November 27, 2017

**Re: Industrial Water Engineering
Erosion and Sediment Control Plan
Engineer's Stamp Date 11-17-17 (C16E006LL)**

11/17/17 Engineer Stamp	INDUSTRIAL WATER ENGINEERING	
	PROJECT TITLE	
	ALBUQUERQUE, BERNALILLO COUNTY, NM	
	CITY, COUNTY, STATE	
	11/17/17	DATE
	C. DURKIN	DRAWN BY
	 inspections Plus, Inc.

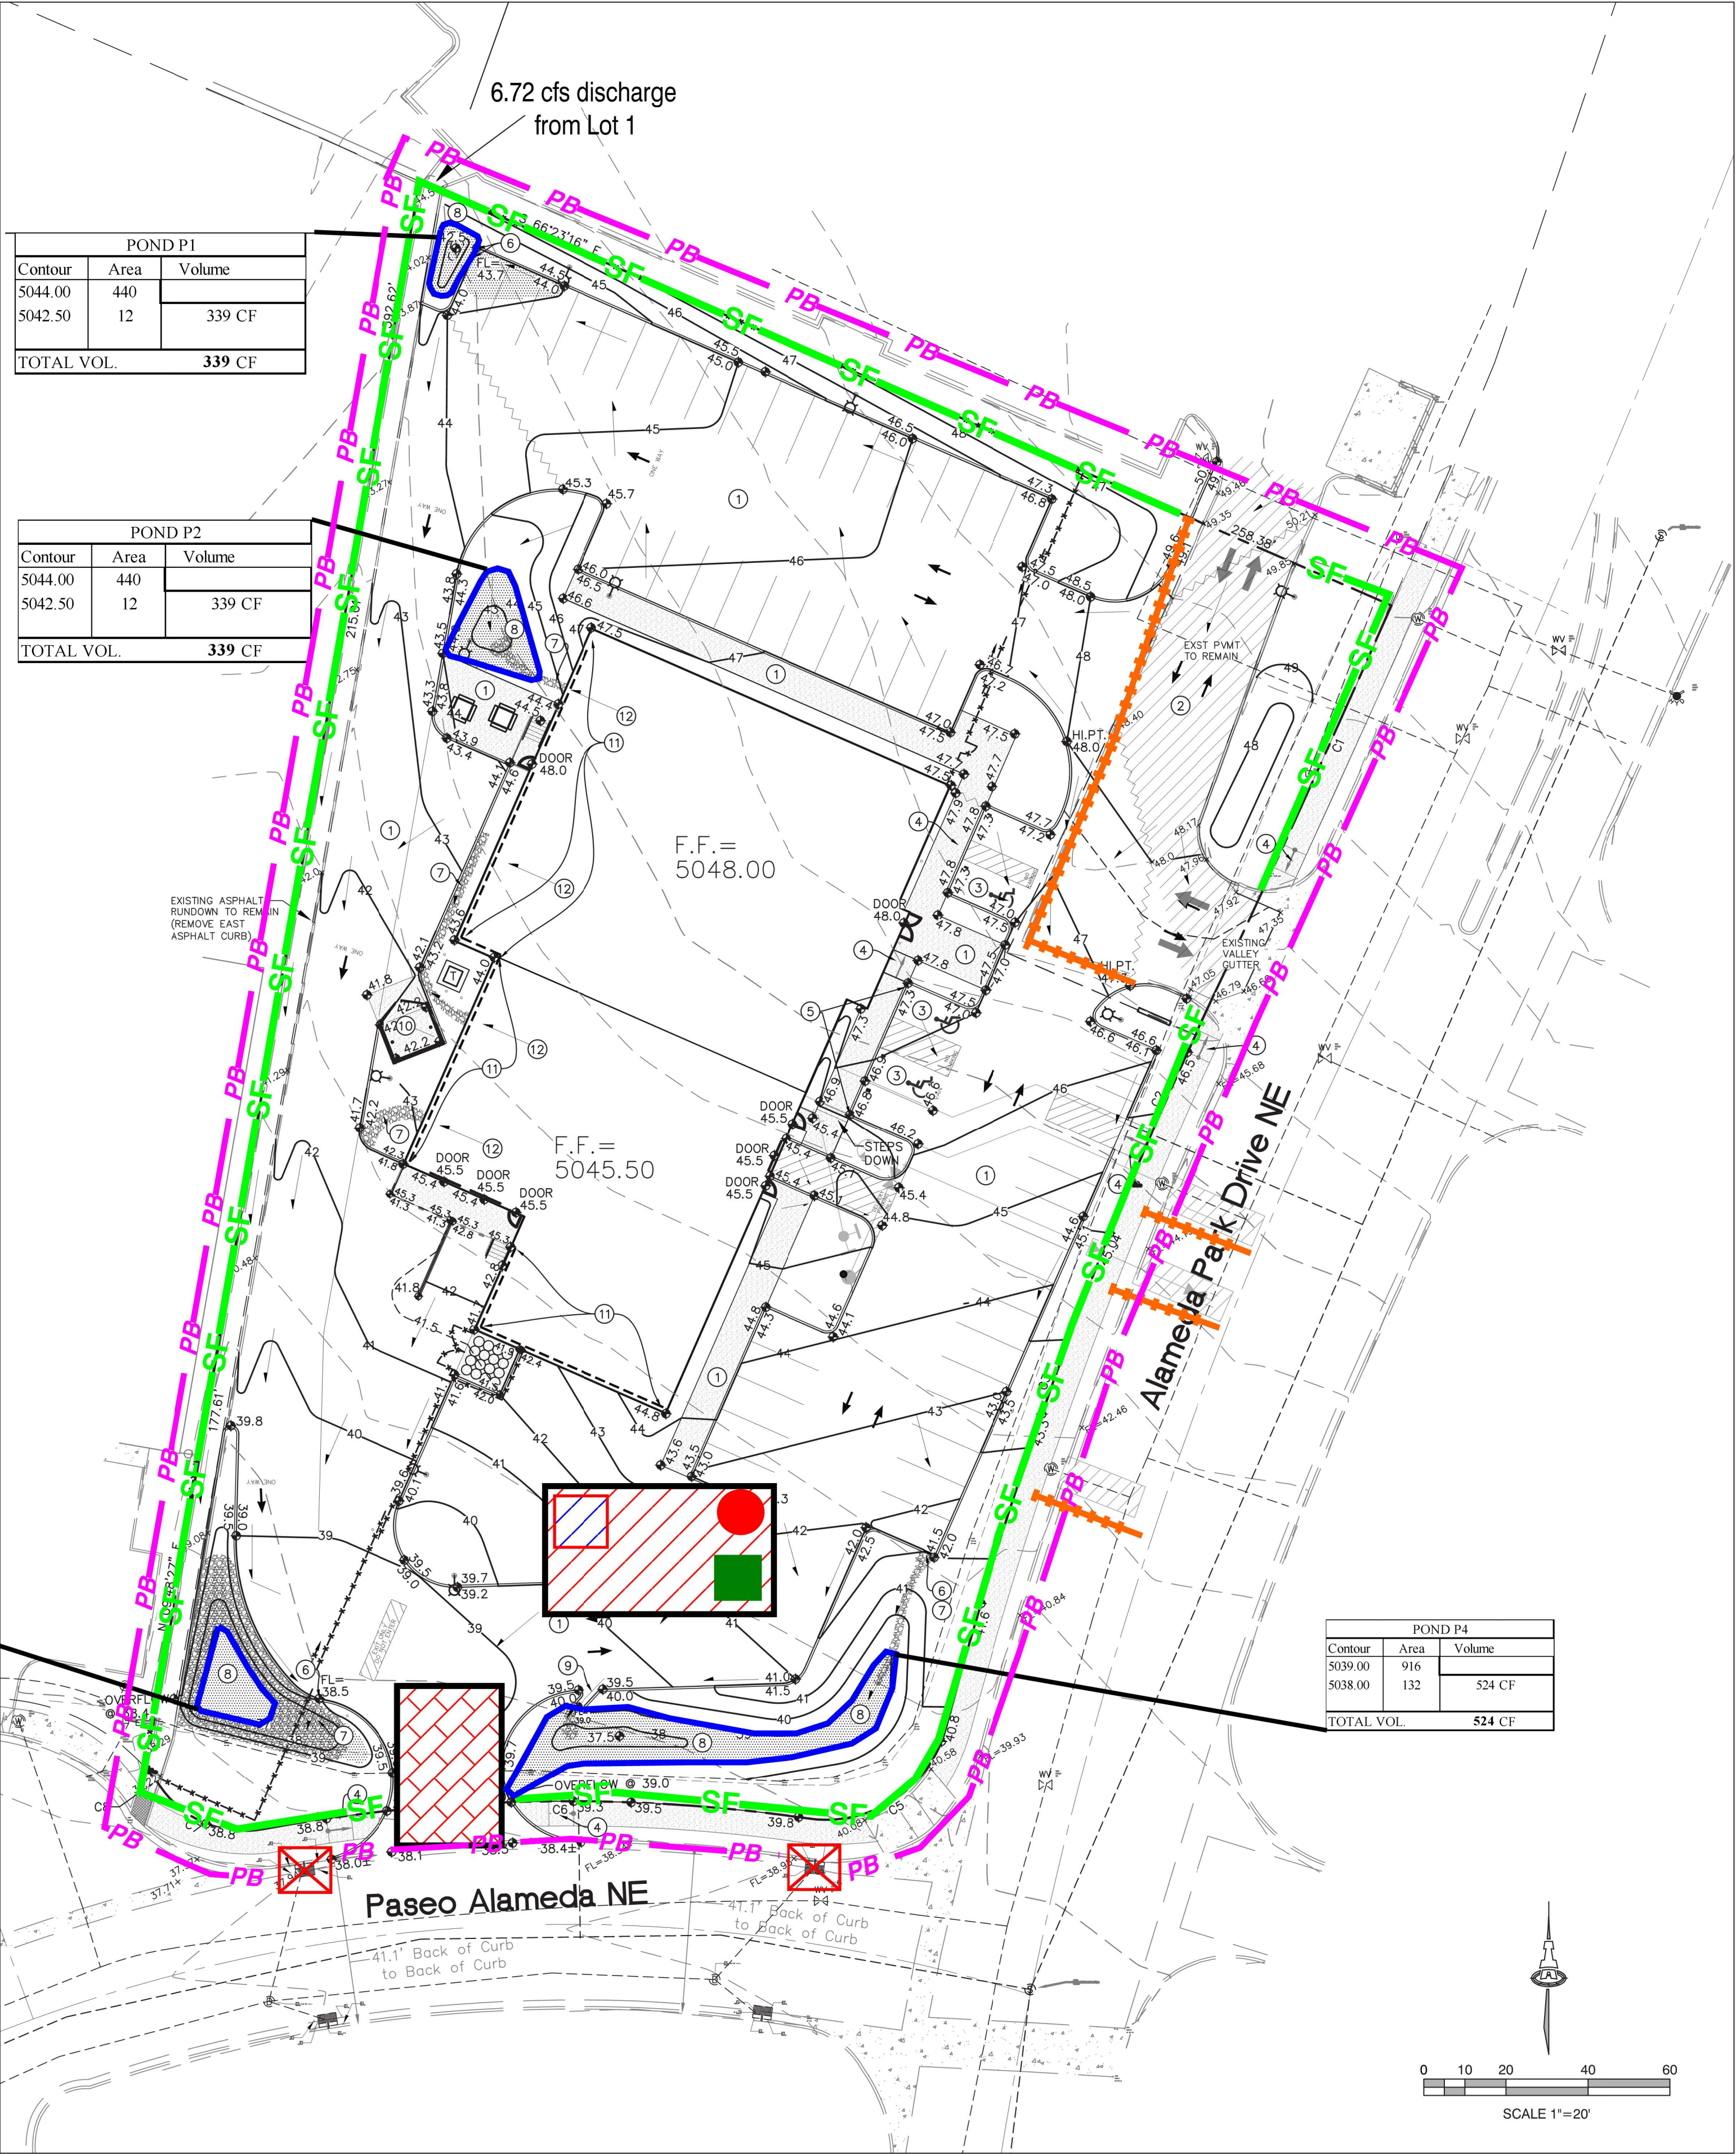
Please discuss the possibility of relocating the track-out pad to the northeast area of the site with the contractor, since it is uphill.
